Aquind Interconnector Nationally
Significant Infrastructure Project Examination: Deadline 7c (15 February 2021)

Response at Deadline 7c General Paper

15 February 2021

Figure 15.49: Indicative Landscape Mitigation Plan Option B(1) (south)

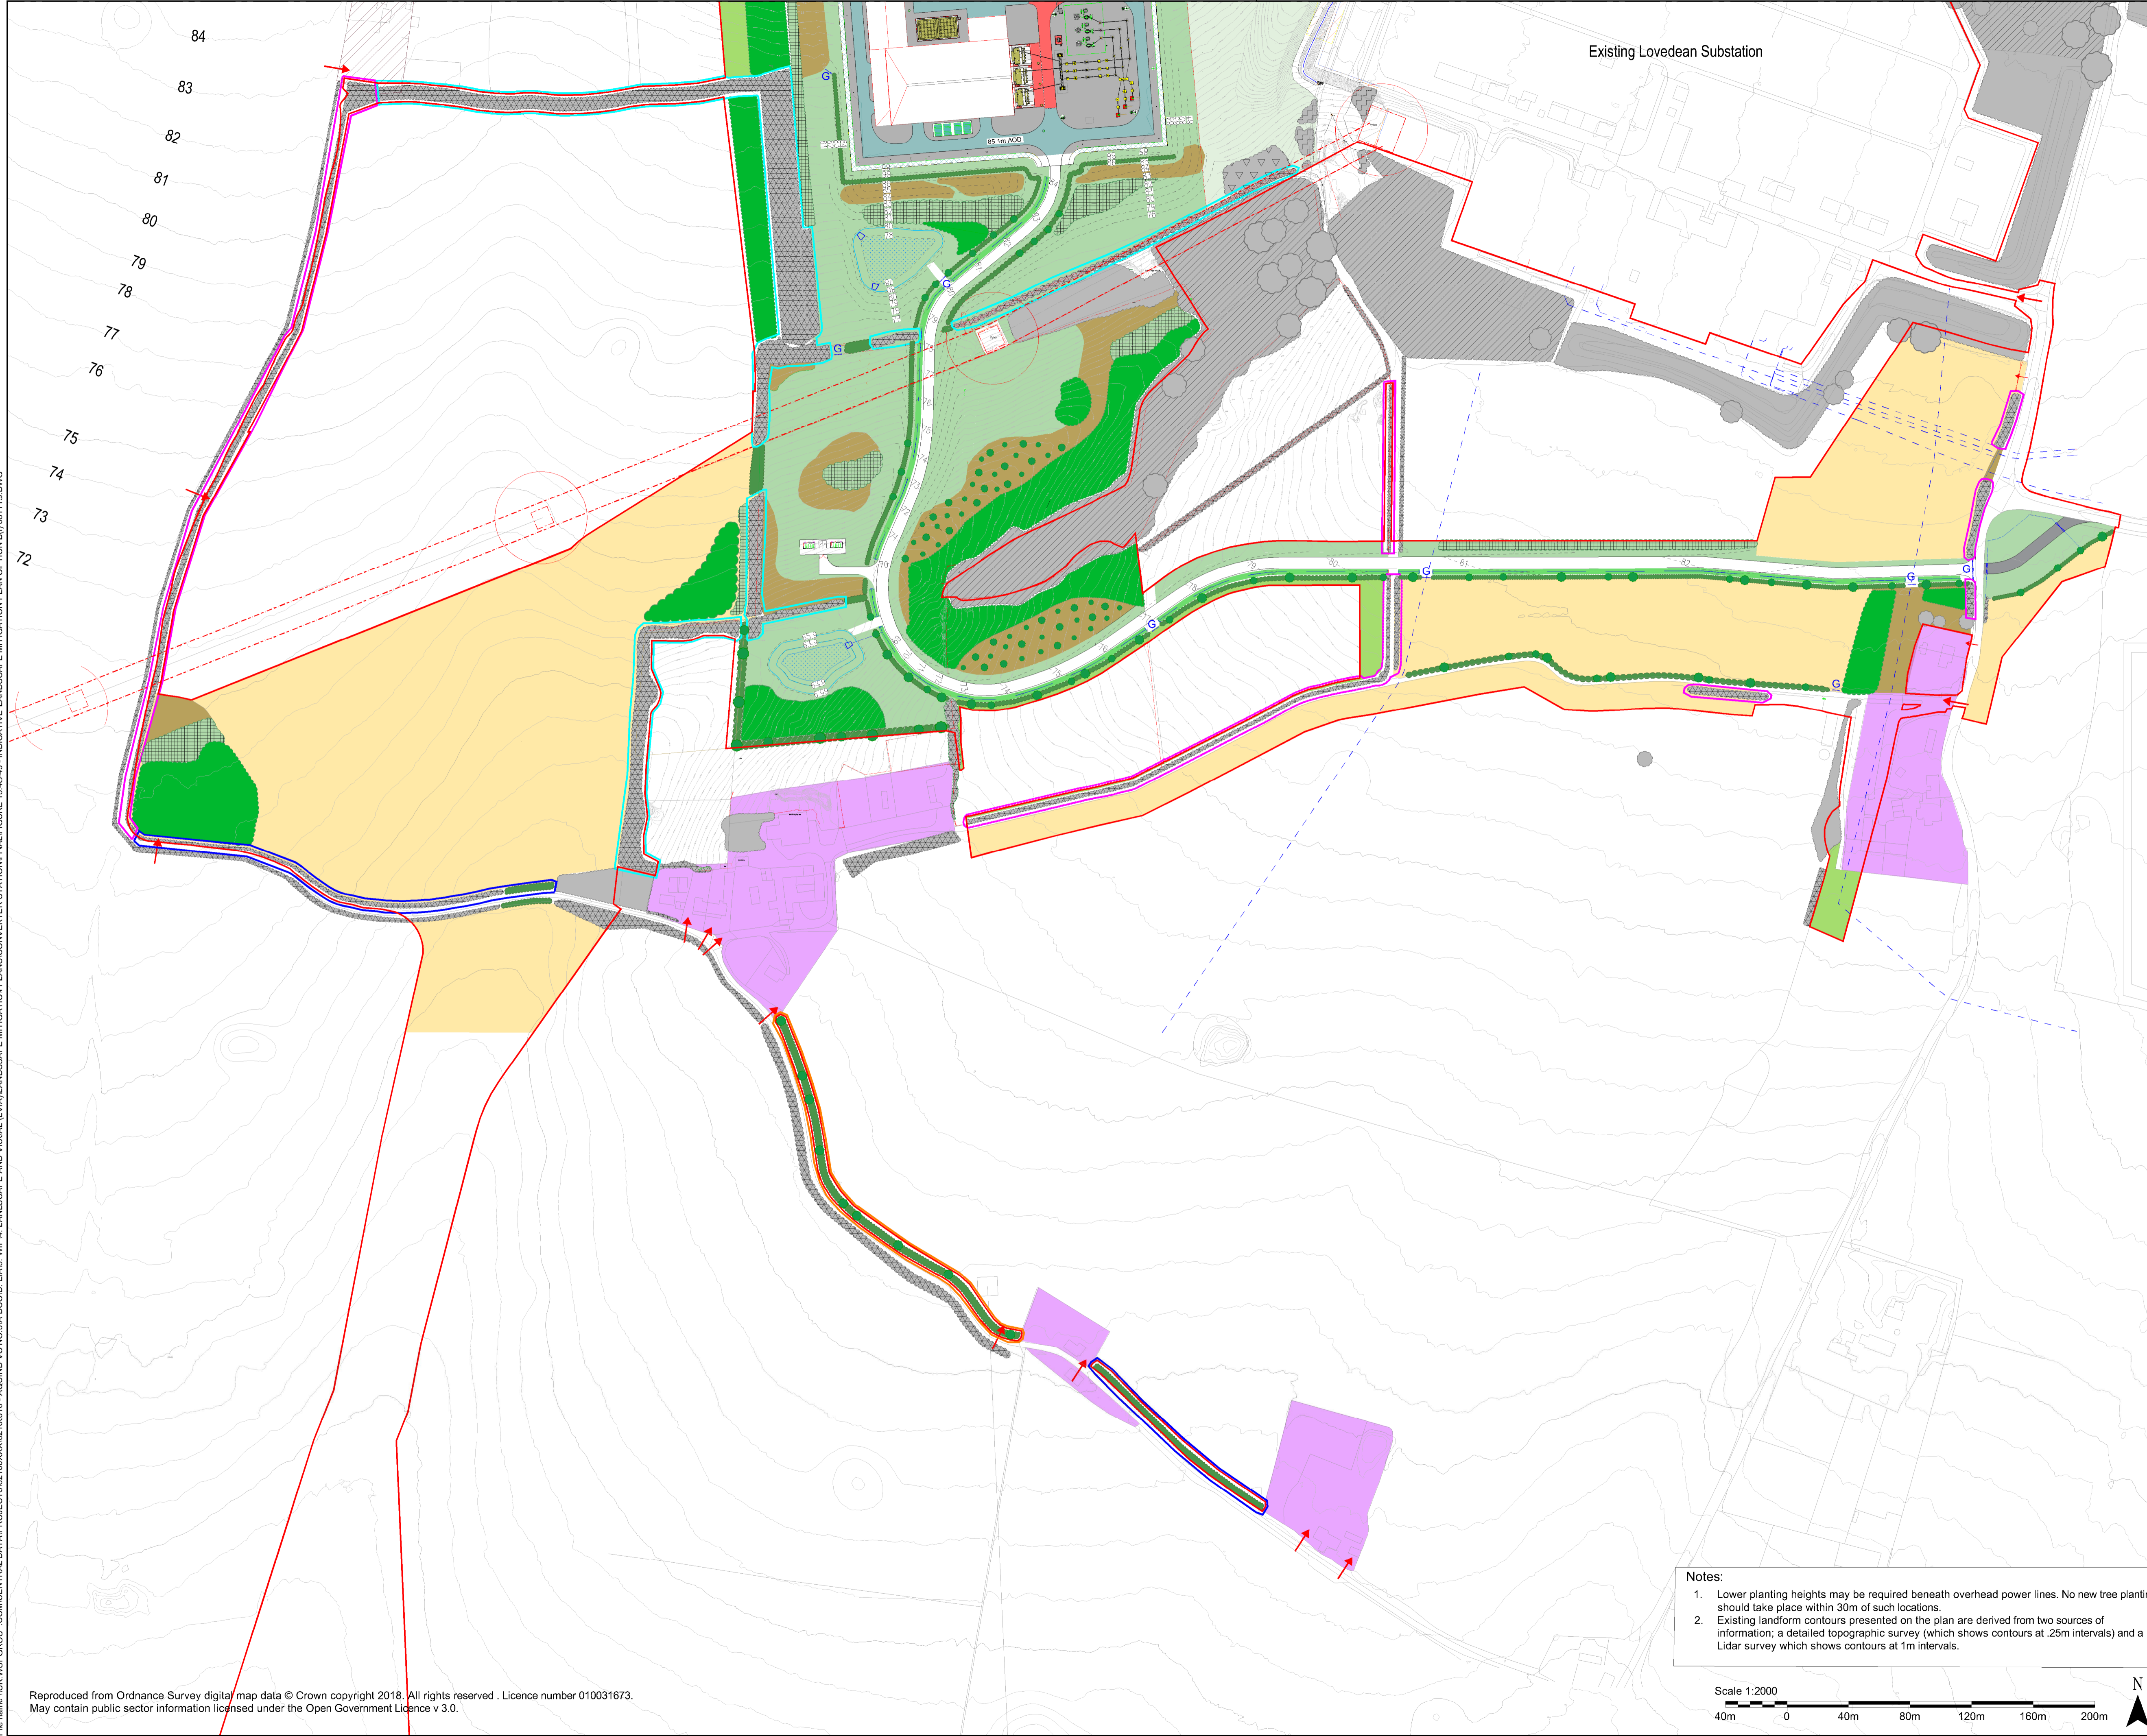
- 8.1 The ExA will recall that the application has presented the two micro siting options of B(i) and B(ii) for the Converter Station. The applicant indicated a preference for option B(ii) that would see the Converter Station positioned closer to the existing substation with the positive outcome that an existing hedgerow with trees on the western side could then be retained. This feature would be lost with option B(i). The applicant indicated that discussion where ongoing with the National Grid with a view to signing off the agreement to allow option B(ii) to move forward as the adopted proposal, before the end of the Examination. The Council notes that these negotiations have not been concluded and wishes to express its view that these discussions should be resolved as a matter of urgency.

- 8.2 In the event that the Examination closes with this matter unresolved, it is assumed that the ExA will consider the suitability of either option. The Council wishes to place on record its objections to option B(i) as this is considered to both result in the loss of a well-established landscape feature and open up the proposed Converter Station to view from the west. The full impacts of the loss of this feature where set out in Section 4.6.9 of the Councils local impact report (REP1-183).
